Your Ref: 2025/90517

Our Ref: A/01470

17th July 2025

Land off Forge Lane, Thornhill Lees, Dewsbury - (KIRK) Outline application, including the consideration of access and layout, for two commercial units (use class B2 and/or B8) and associated works

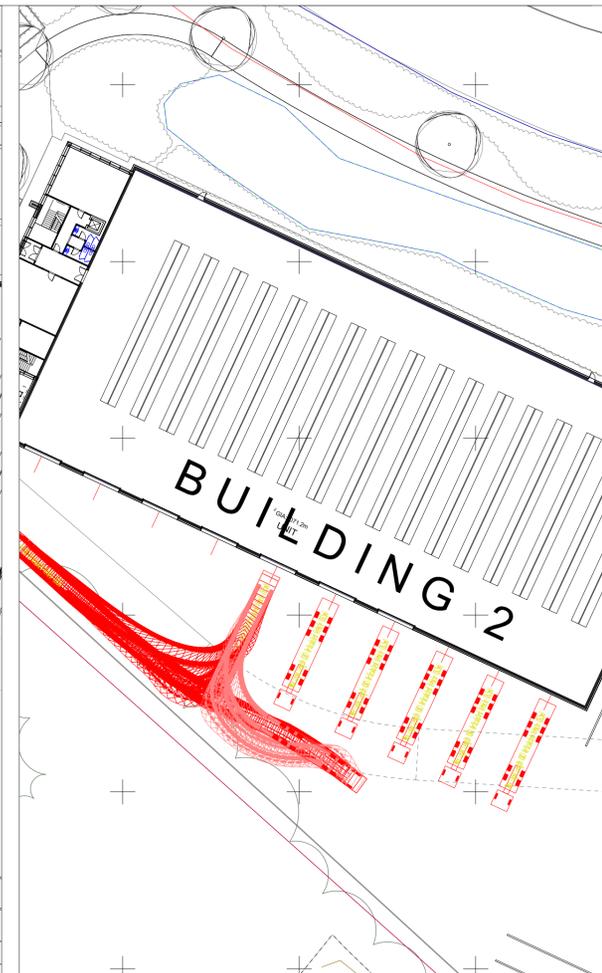
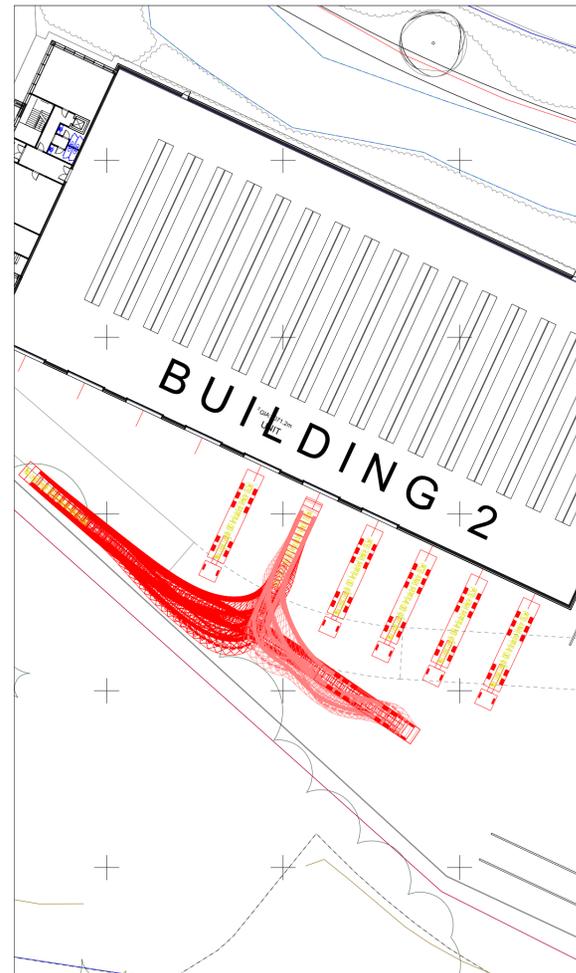
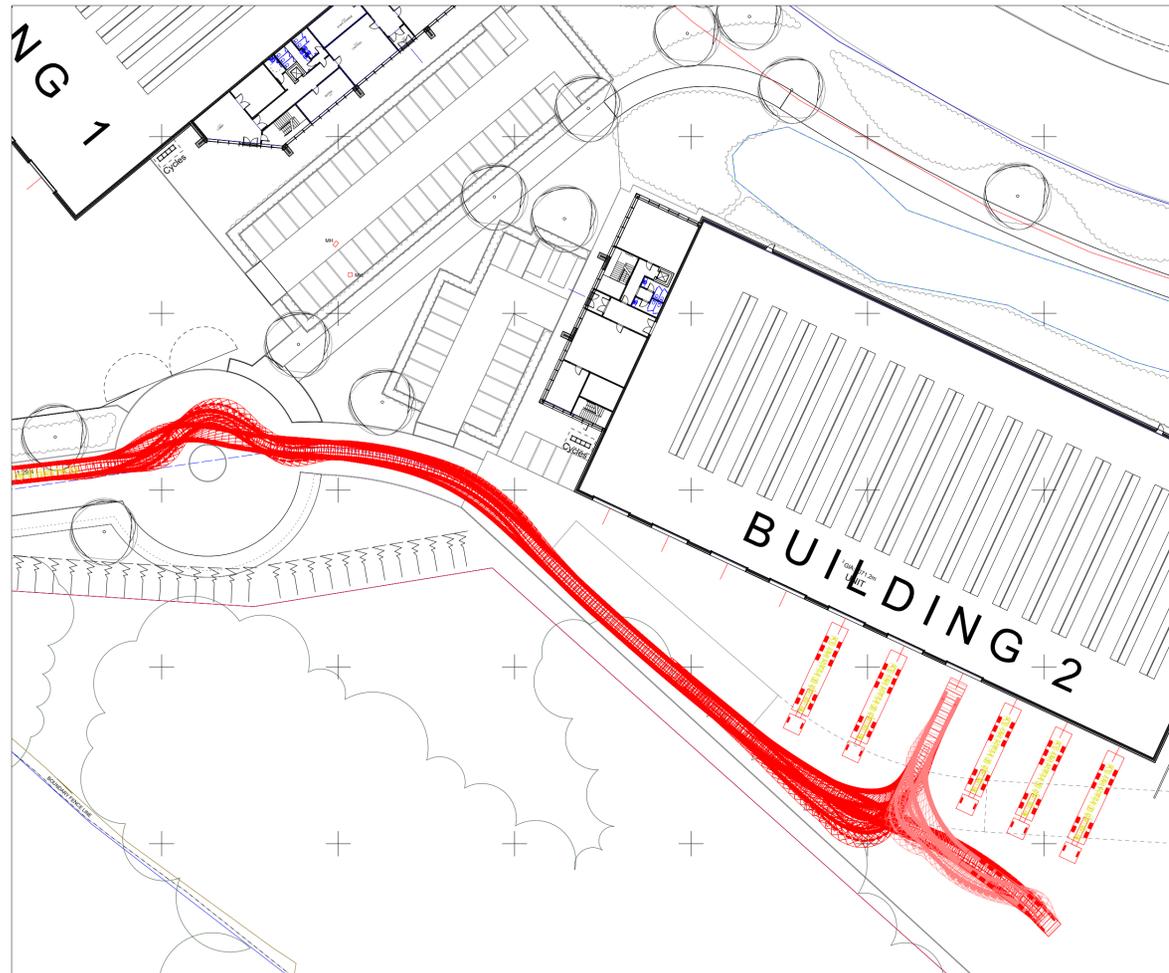
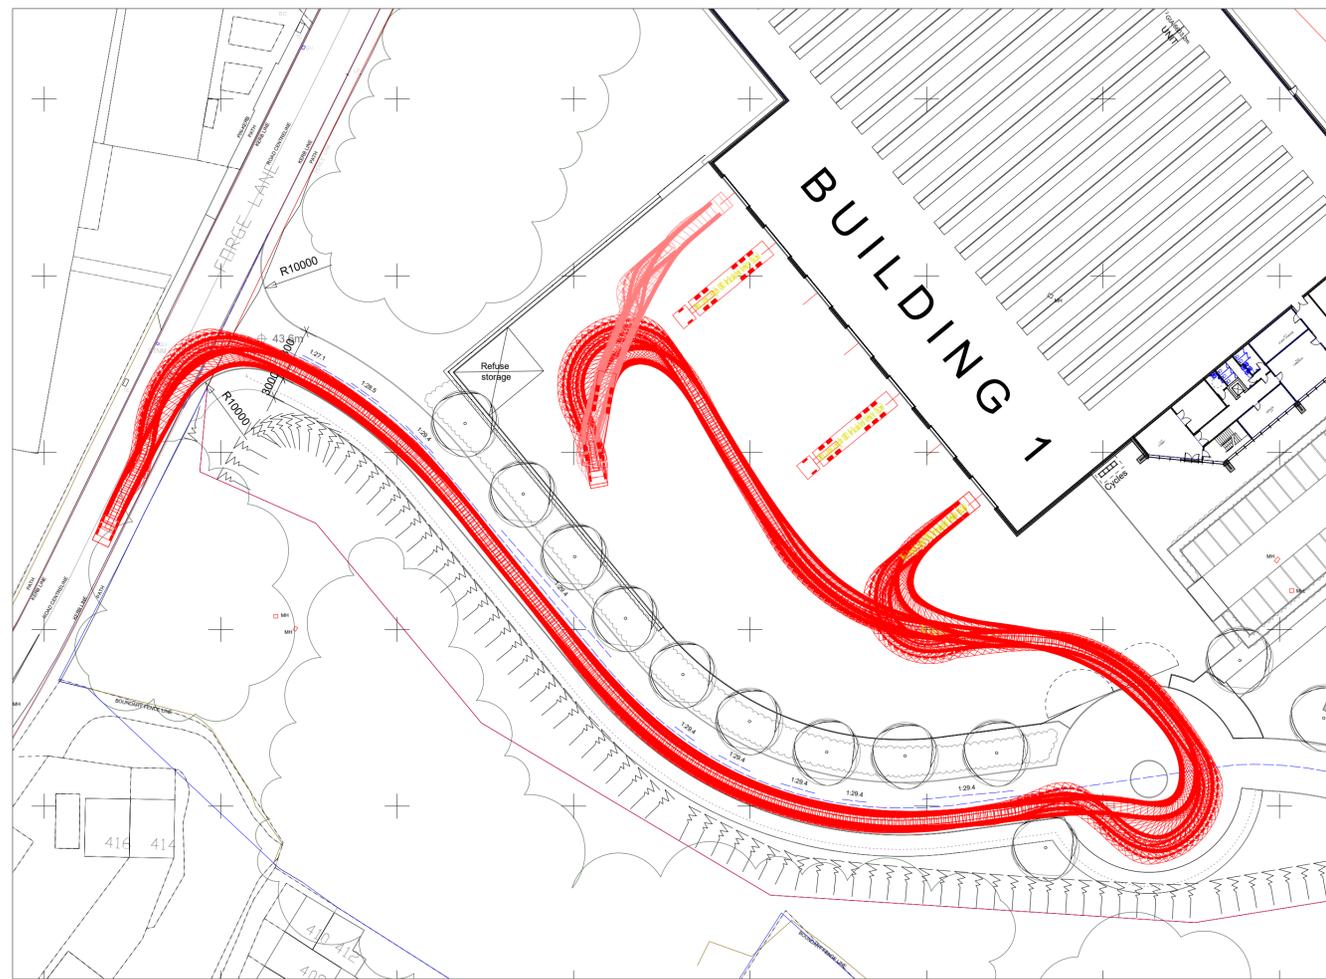
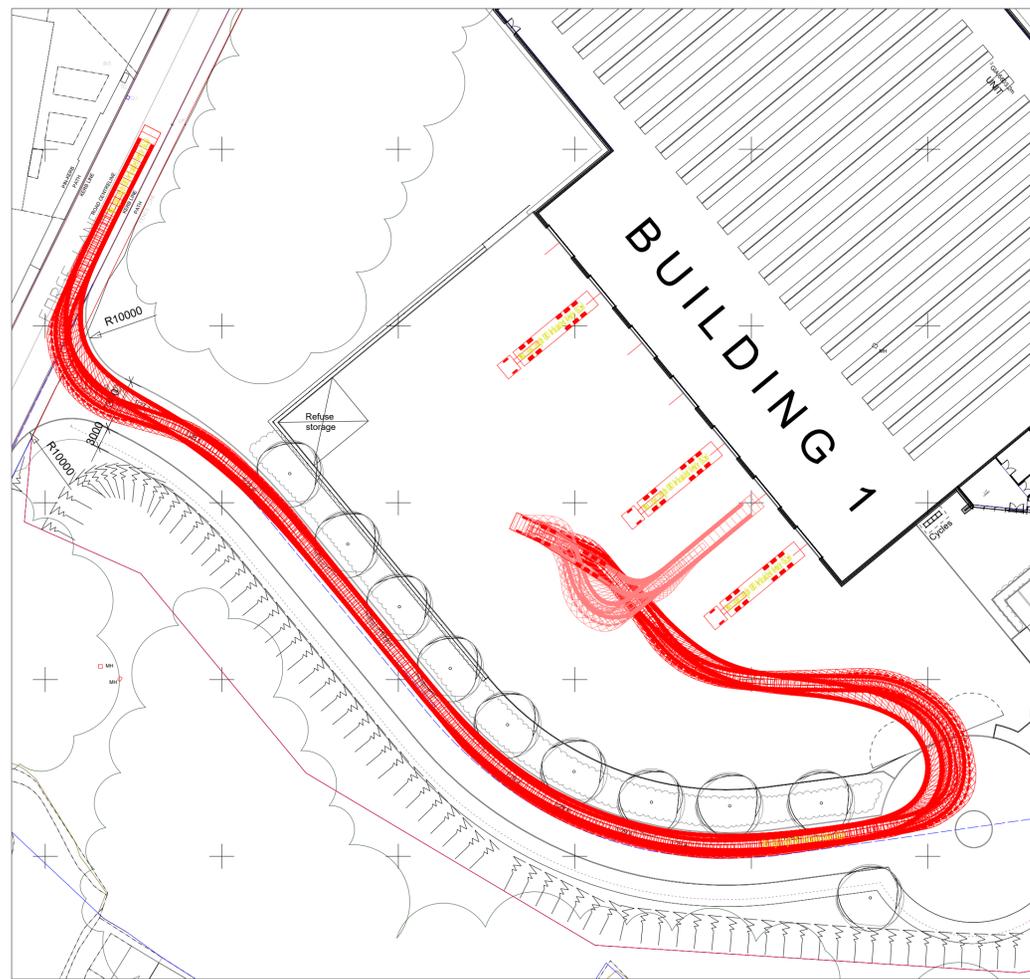
Further to this, it appears from the submitted site layout (drawing number 2776(1)003 (revision J) dated 28/05/2025 that has been prepared by KS Architects) that building 1 will be sited in close proximity/ over the 450mm diameter public surface water sewer located within the site. This could seriously jeopardise Yorkshire Water's ability to maintain the public sewerage network and is not acceptable. We therefore OBJECT to the development layout as currently shown.

3) On the Statutory Sewer Map, there is a 225 mm diameter public combined sewer, a 225 mm diameter surface water and 375mm, upsizing to 450mm diameter surface water sewer recorded to cross the site. It is essential that the presence of this infrastructure is taken into account in the design of the scheme.

- c) Regarding the 225mm diameter public combined sewer, a stand-off distance of 3 (three) metres is required at each side of the sewer centre-line and it may not be acceptable to raise or lower ground levels over the sewer, nor to restrict access to the manholes on the sewer.

- d) Regarding the 375mm diameter, upsizing to 450mm diameter public surface water sewer, a stand-off distance of 3.5 (three point five) metres is required at each side of the sewer centre-line and it may not be acceptable to raise or lower ground levels over the sewer, nor to restrict access to the manholes on the sewer.
